V2_Drainage Report - Final_COMMENTS.pdf Markup Summary

Ascent Church

Final Drainage Report

PCD File No: PPR265

# ASCENT CHURCH PCM APPLICABILITY MAP

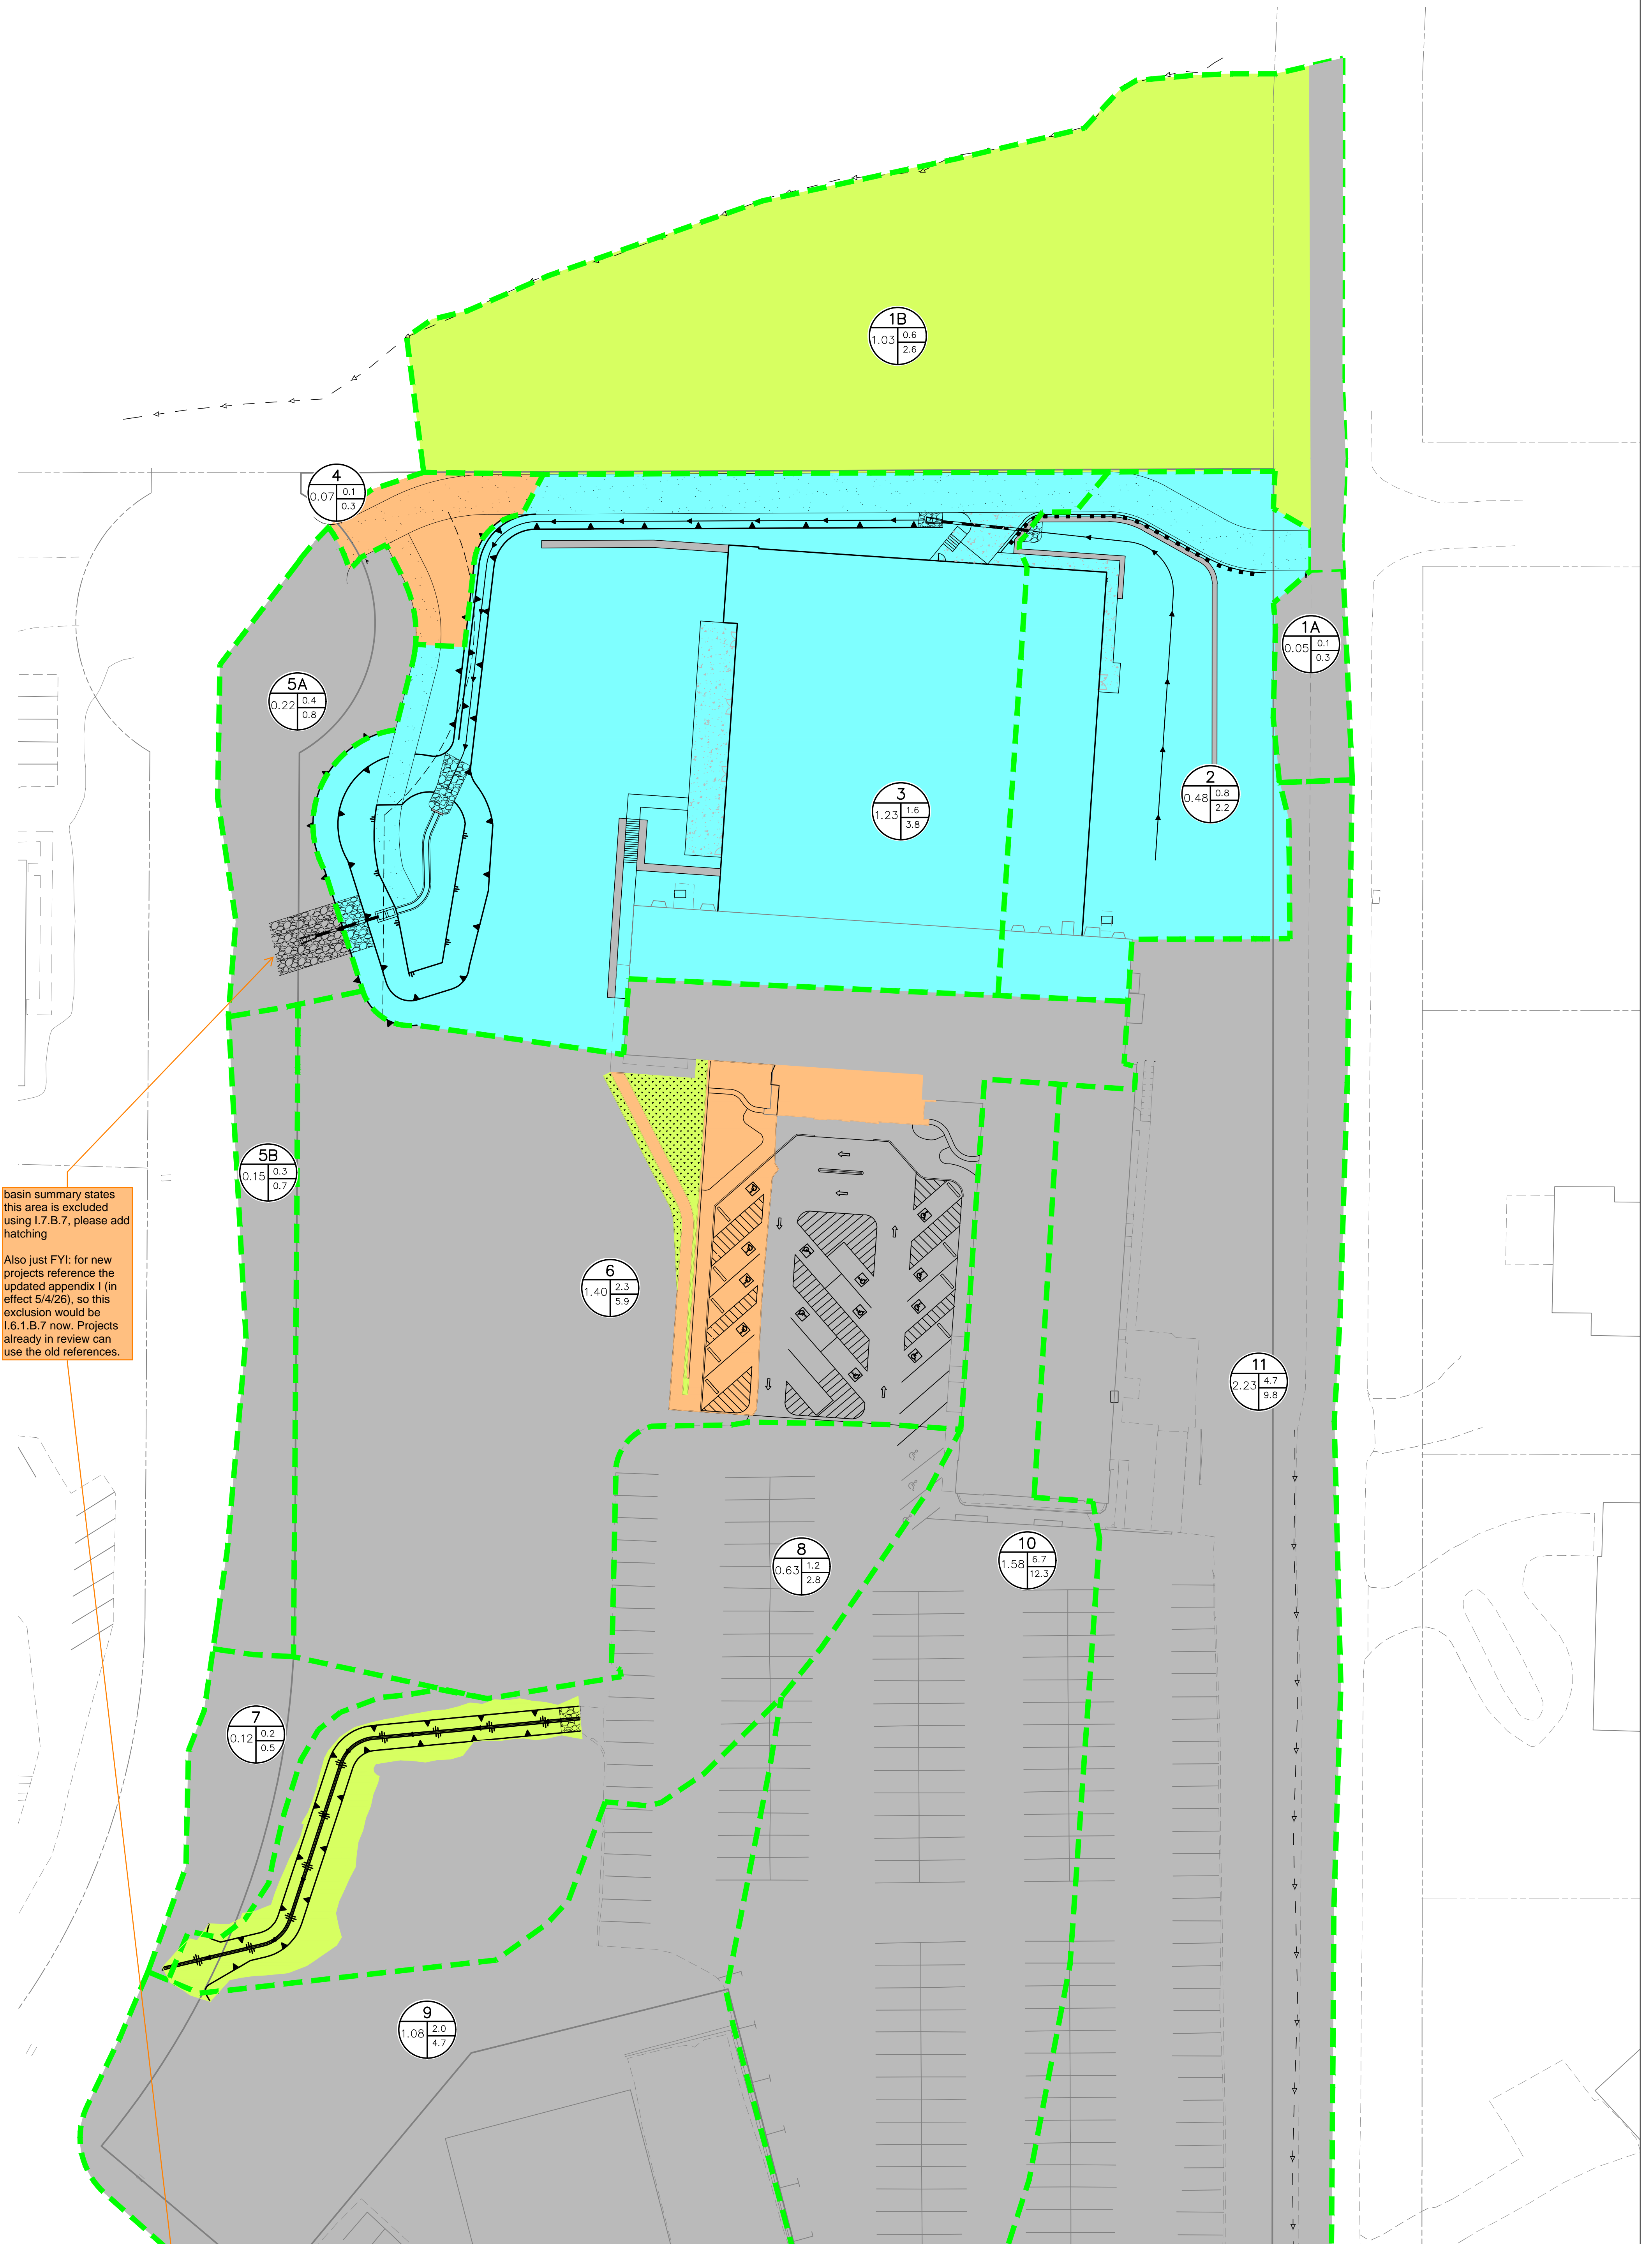
basin summary states this area is excluded using I.7.B.7, please add hatching

Also just FYI: for new projects reference the updated appendix I (in effect 5/4/26), so this exclusion would be I.6.1.B.7 now. Projects already in review can use the old references.
